CITY OF PORTLAND BUILDING PERMIT

Located At 93 WESTLAND AVE

Job ID: 2011-07-1652-ALTR

RE: 93 Westland Avenue Renovation project

SK-1  
1 OF 5

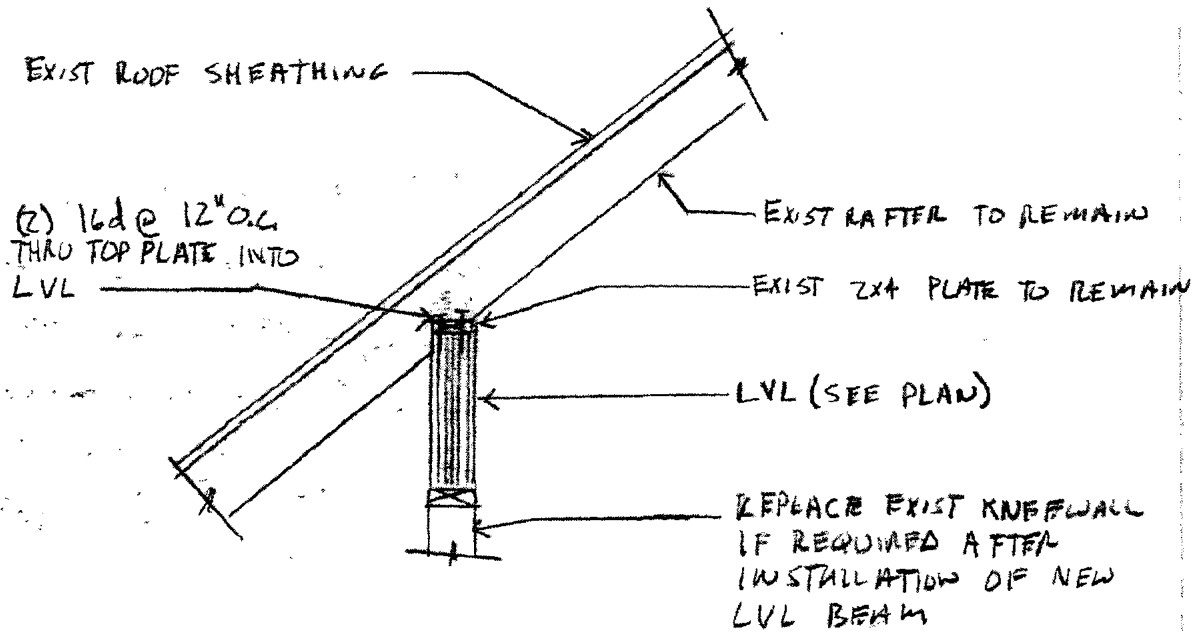
The first item I reviewed was a ridge beam running from the southwest side of the house (labeled Ridge Beam 3 on Sketch SK-1). The ridge beam is a 1 3/4" x 11 7/8" LVL, and spans approximately 23'-0". This existing ridge beam was found to be overstressed according to current building code requirements. It is recommended that the contractor install a vertical support to reduce the span of the ridge beam to meet current building code requirements. The installation of this support is detailed on the attached sketches.

SK-3  
3 OF 5

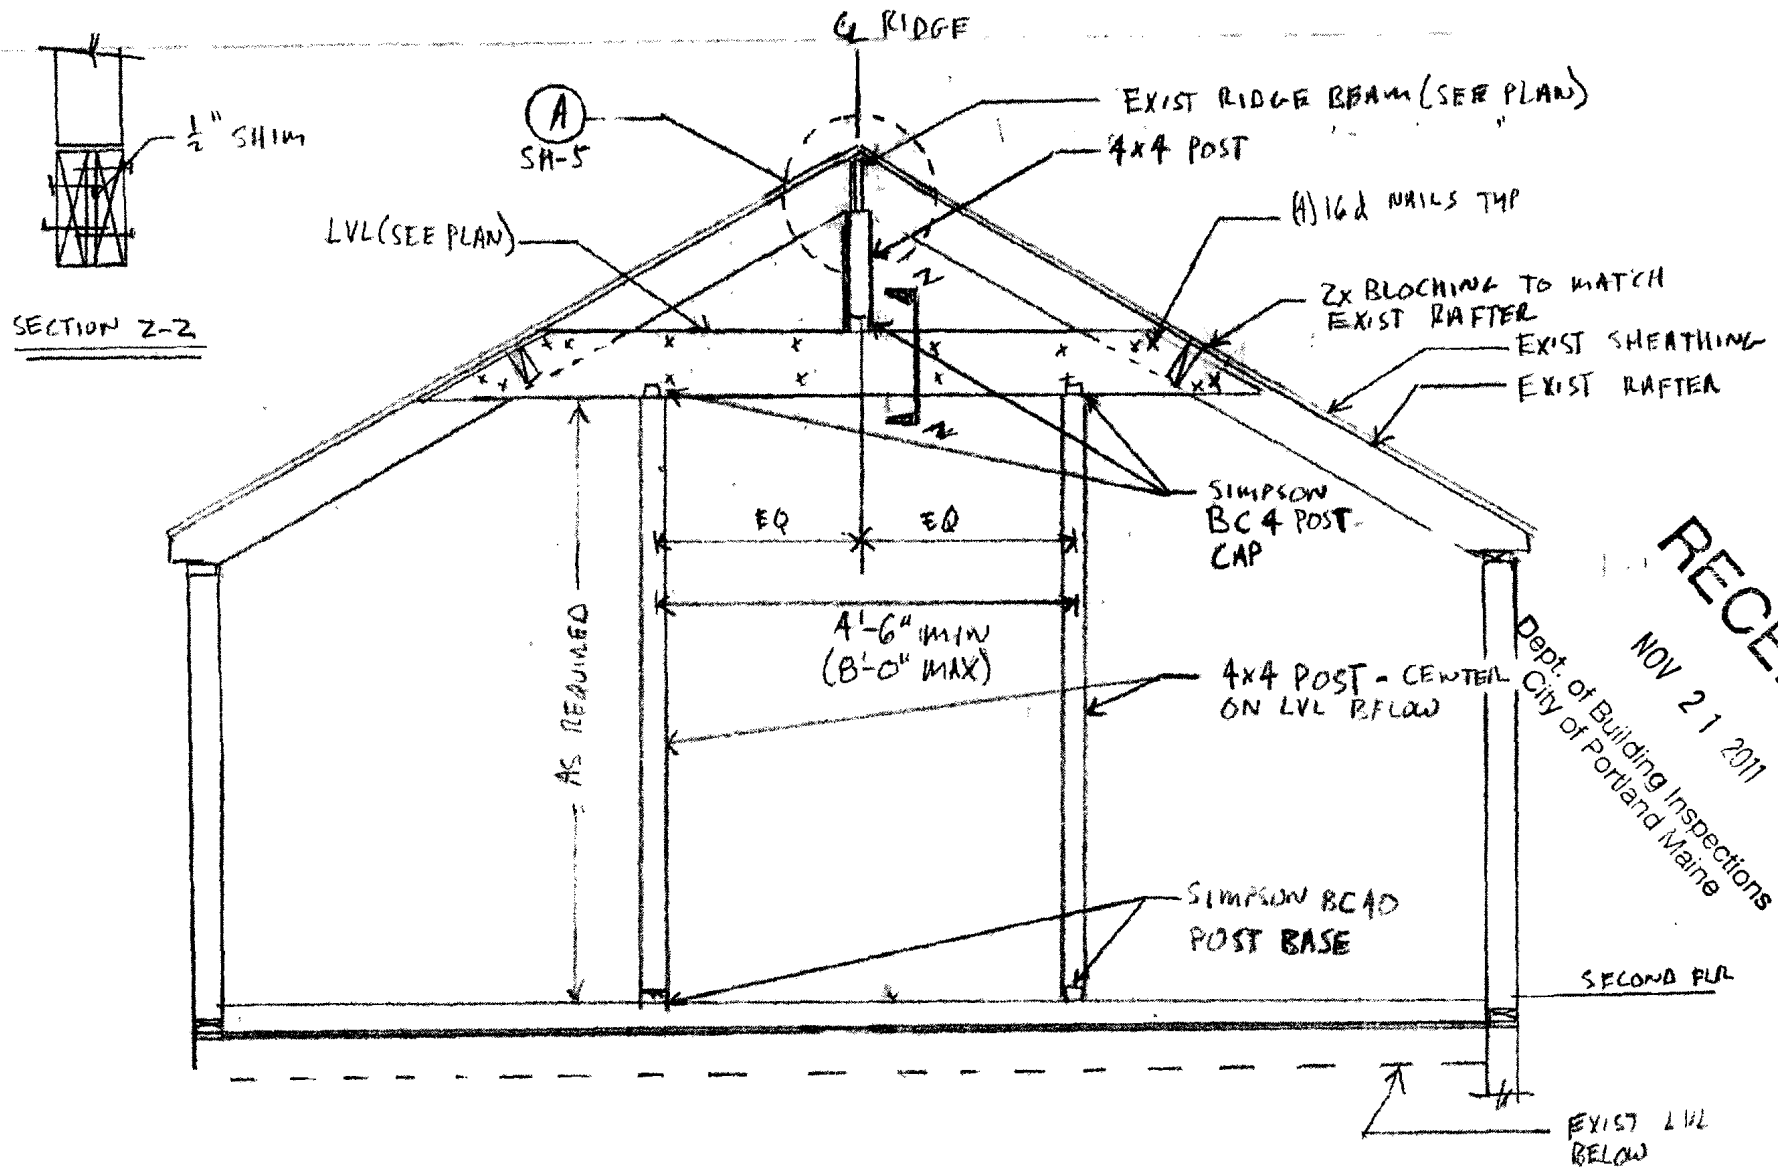
The second issue I reviewed was the roof rafters on the North side of the building. The original roof was reportedly lifted at the ridgeline to allow for more living space on the second floor. The rafters currently bear on the exterior wall at one end, a new knee wall at center span, and a new ridge beam at the other end. The new knee wall at center span is supported by the second floor framing. New rafters were sistered alongside the existing rafters to span from the knee wall to the center ridgeline. Upon review of this framing for code compliance, I found that the floor below the knee wall lacked the structural capacity to carry the roof loads from above. I recommend removing the existing knee wall and installing two LVL beams to remove the roof load from the existing floor framing. Details of this recommended repair are shown on the attached sketches.
